Further to the Highway Officer's comments, please find submitted Revised Drawing Rev B – Proposed Landscape and Site Plan.

PEOPOSED SITE PLAN
SCALE 1:100
SITE BOUNDARY :

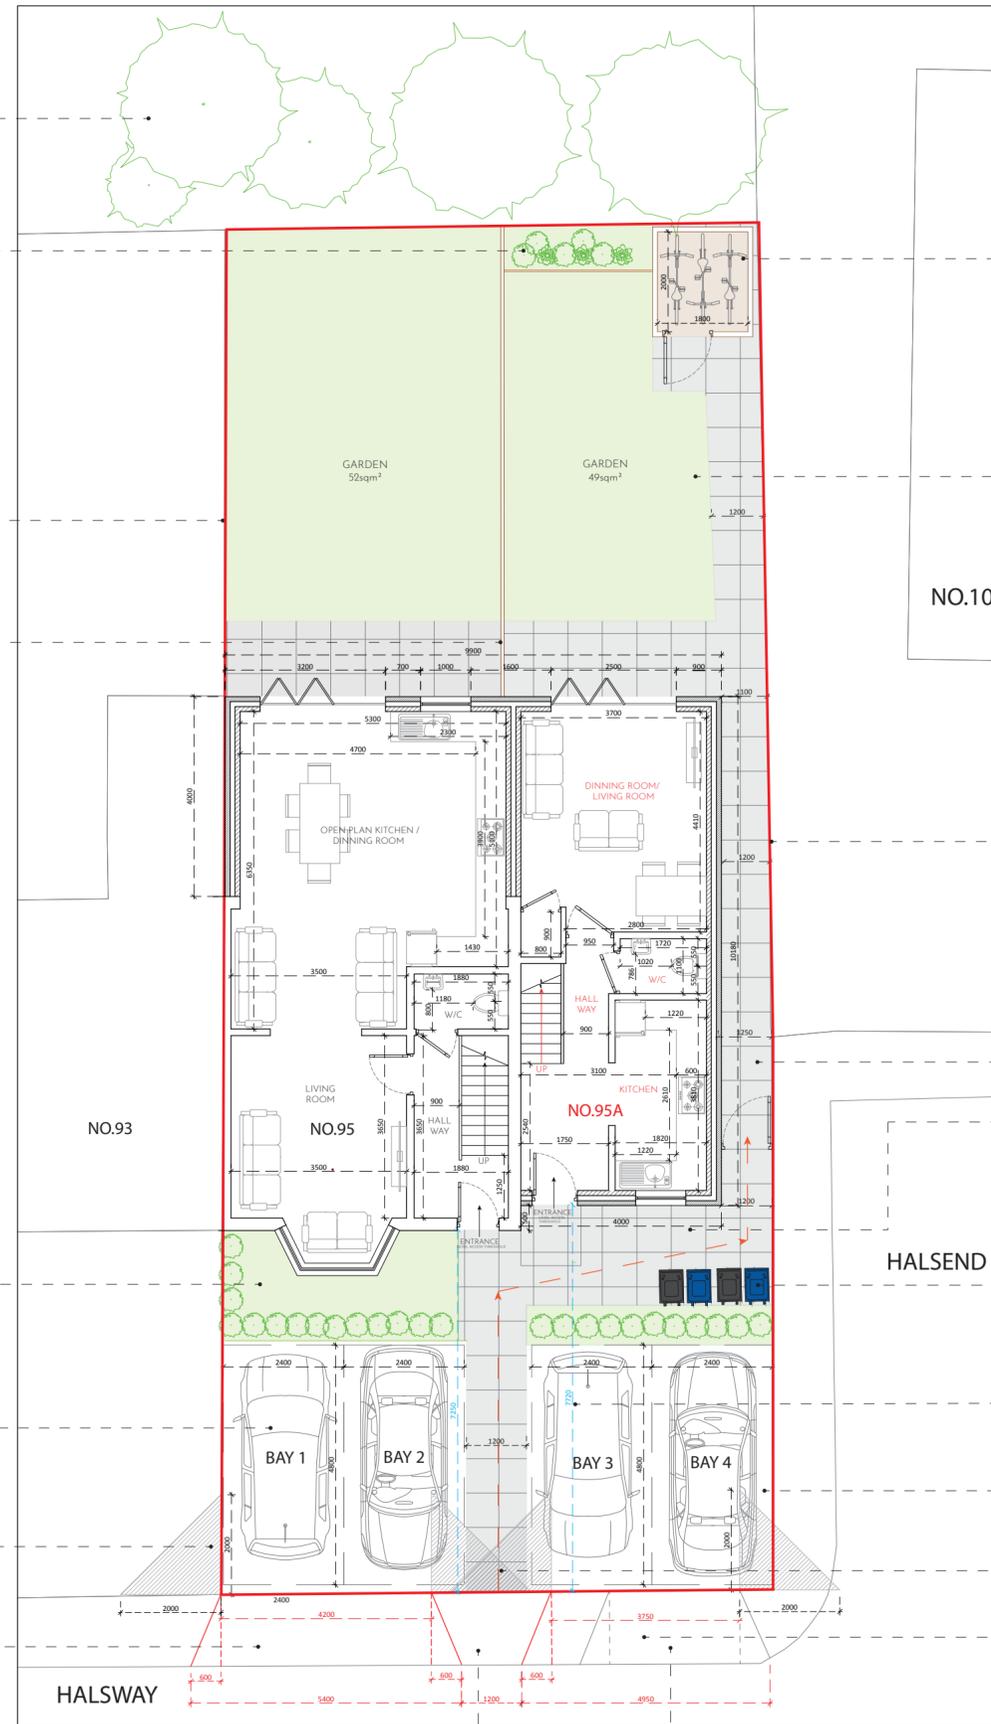
Policy-compliant parking provision in accordance with London Plan Table 10.3 and Hillingdon Local Plan Part 2 Policy DMT6;

Separate vehicle crossovers with a clearly defined reinstated full-height kerb between them, avoiding a continuous apron and complying with the Council's Domestic Vehicle Footway Crossover Policy;

Clearly dimensioned parking bays and driveway depths, with a swept-path confirmation demonstrating that all spaces are independently accessible and that vehicles can enter and exit in forward gear;

Provision of 2.0m x 2.0m pedestrian visibility splays at each access;

Fully compliant cycle storage in accordance with Policy DMT5 and the London Cycling Design Standards.
